**From:** Julie Oates  
**Sent:** 22 November 2023 15:29  
**To:** Planning Comments; Samantha Yates  
**Cc:** Colin Alden  
**Subject:** 23/03176/FUL | Conversion of an agricultural barn to a dwelling. | Harden Farmhouse Grove Road Penshurst Tonbridge Kent TN11 8DX

### **23/03176/FUL | Conversion of an agricultural barn to a dwelling. | Harden Farmhouse Grove Road Penshurst Tonbridge Kent TN11 8DX**

Existing Ground Floor Plan
 Scale 1:50
 Area ca. 270.83 m²

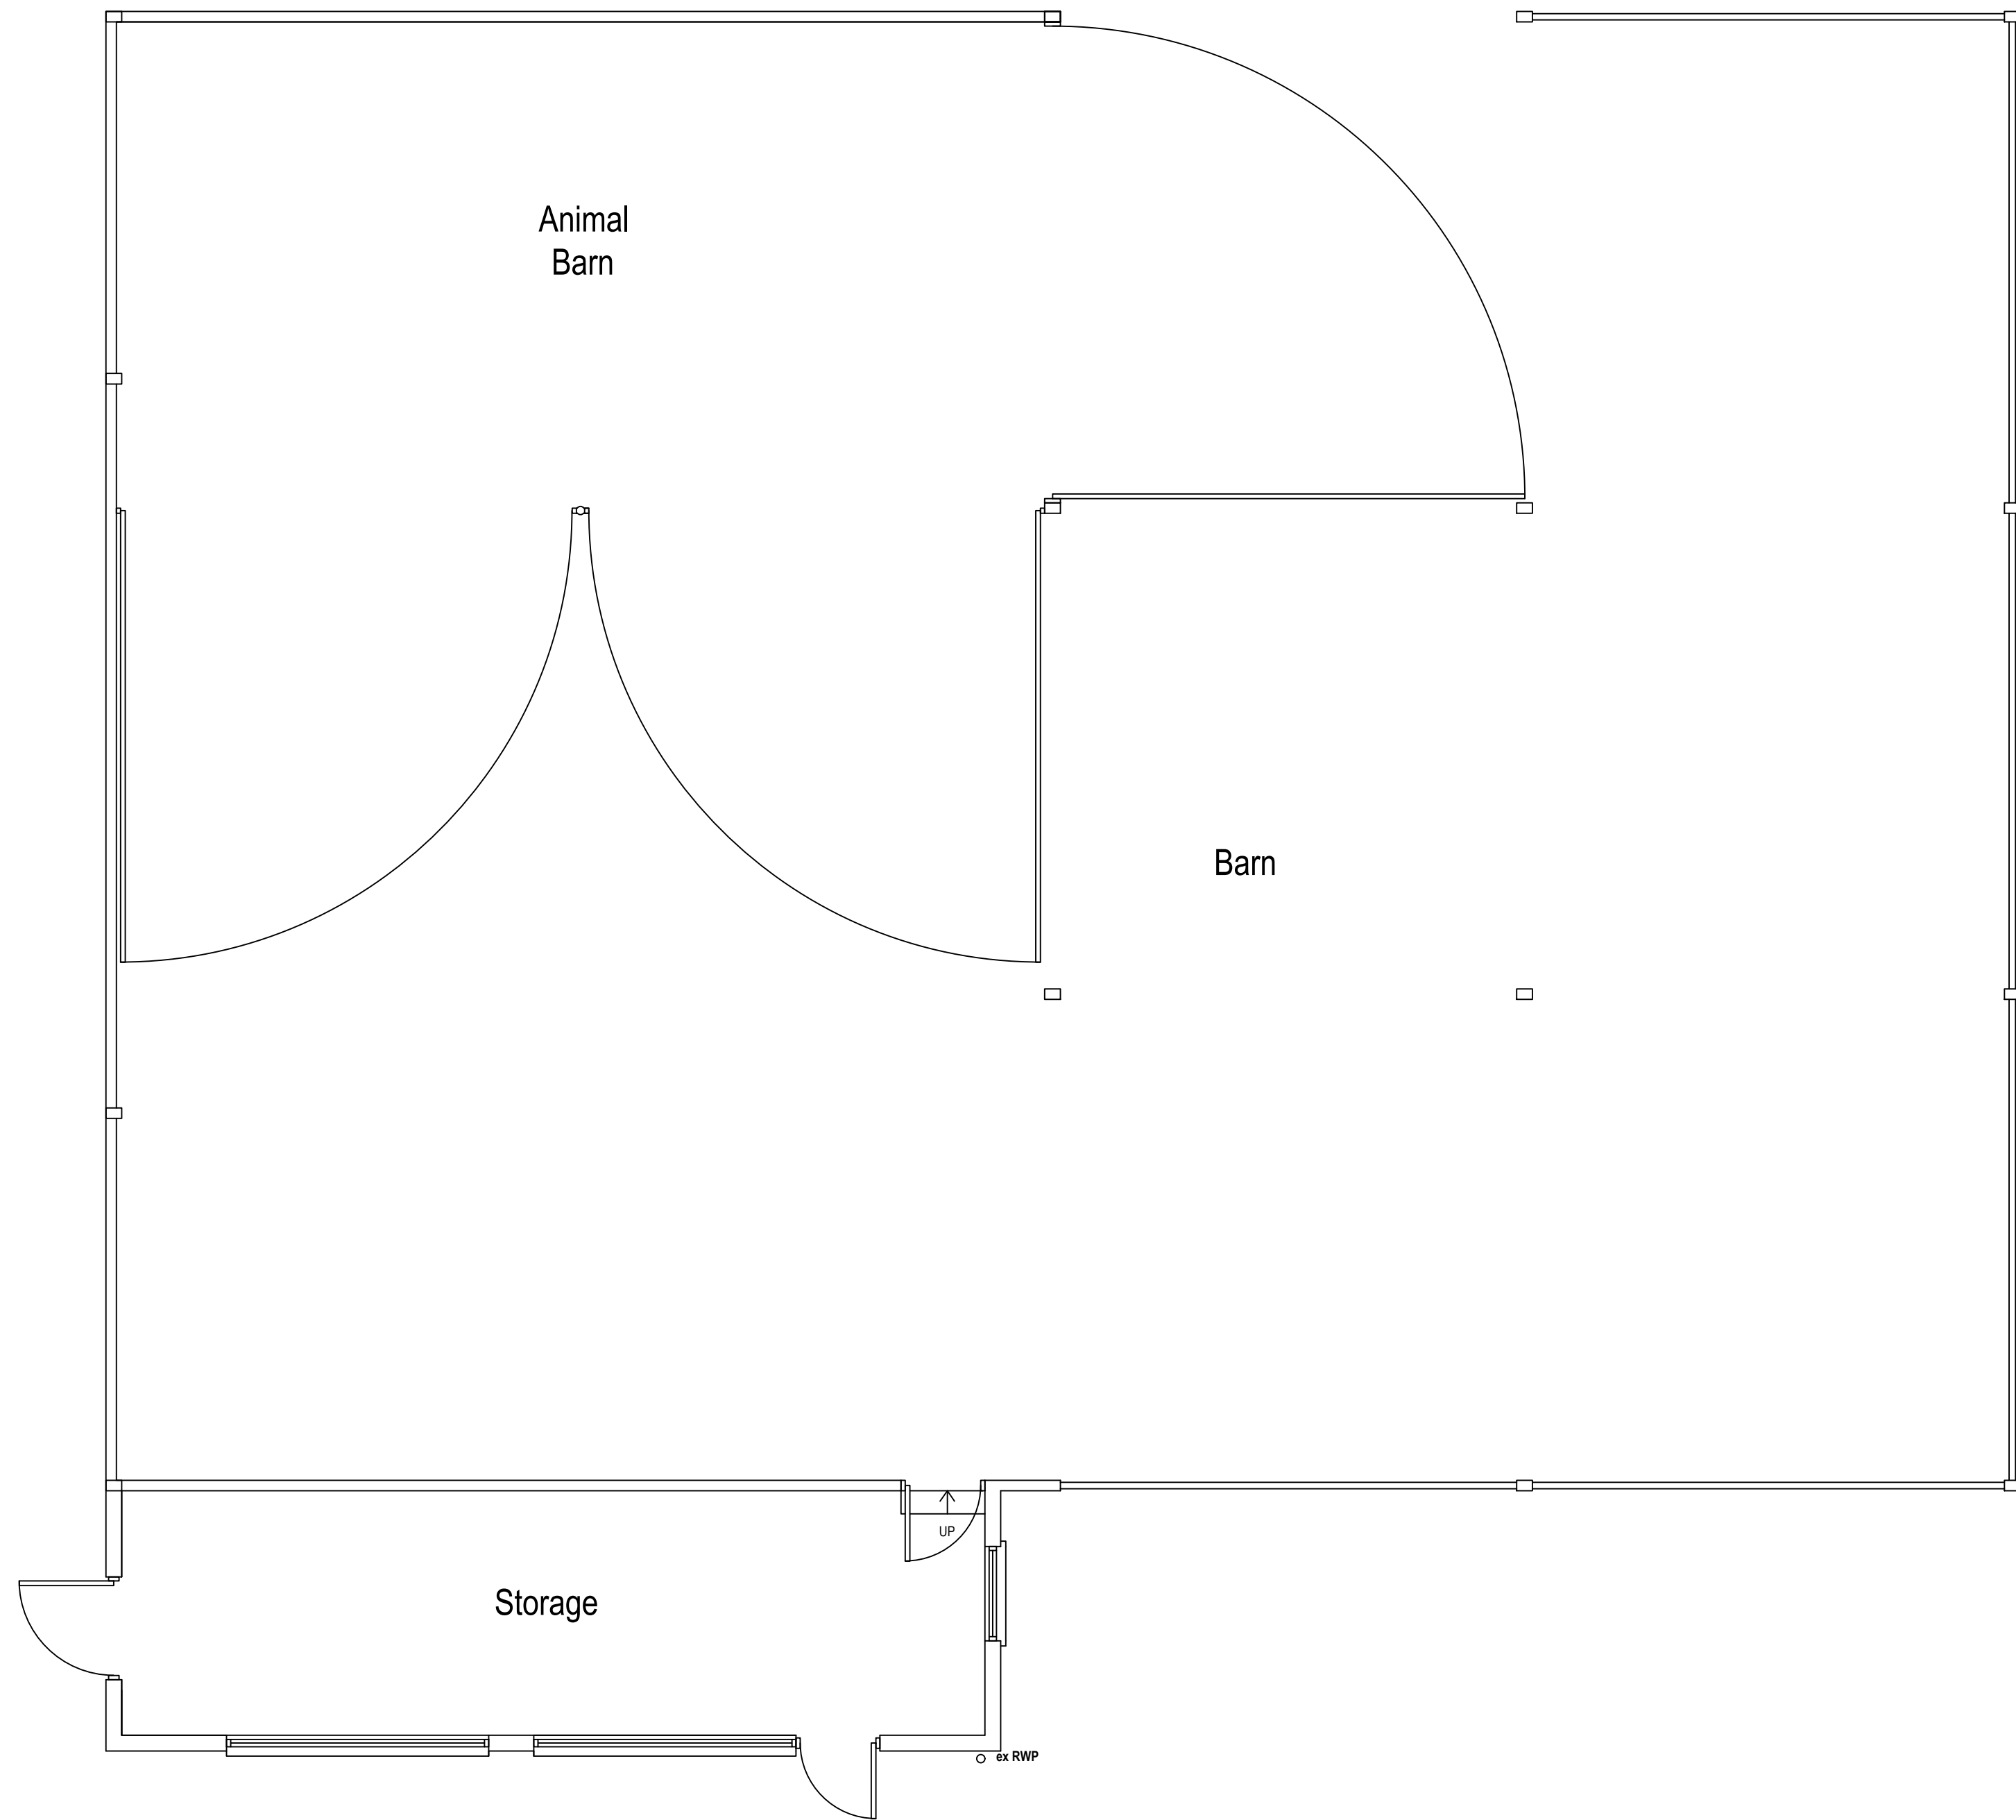
Due to the current and past agricultural use of the site (use of herbicides, pesticides, use/servicing and repair of machinery etc) and the note on the drawings that the barn has been an 'animal barn', a contaminated land assessment will be required. The assessment should follow a phased risk based approach staged approach. Phase 1 should include a desk based assessment including a risk assessment and conceptual site model. The findings of this will determine whether a Phase 2 intrusive investigation, any remediation, a Remediation Strategy and Closure Report are required. In order to ensure that any potential contamination is investigated and dealt with satisfactorily, an appropriately worded condition should be attached to any planning permission.
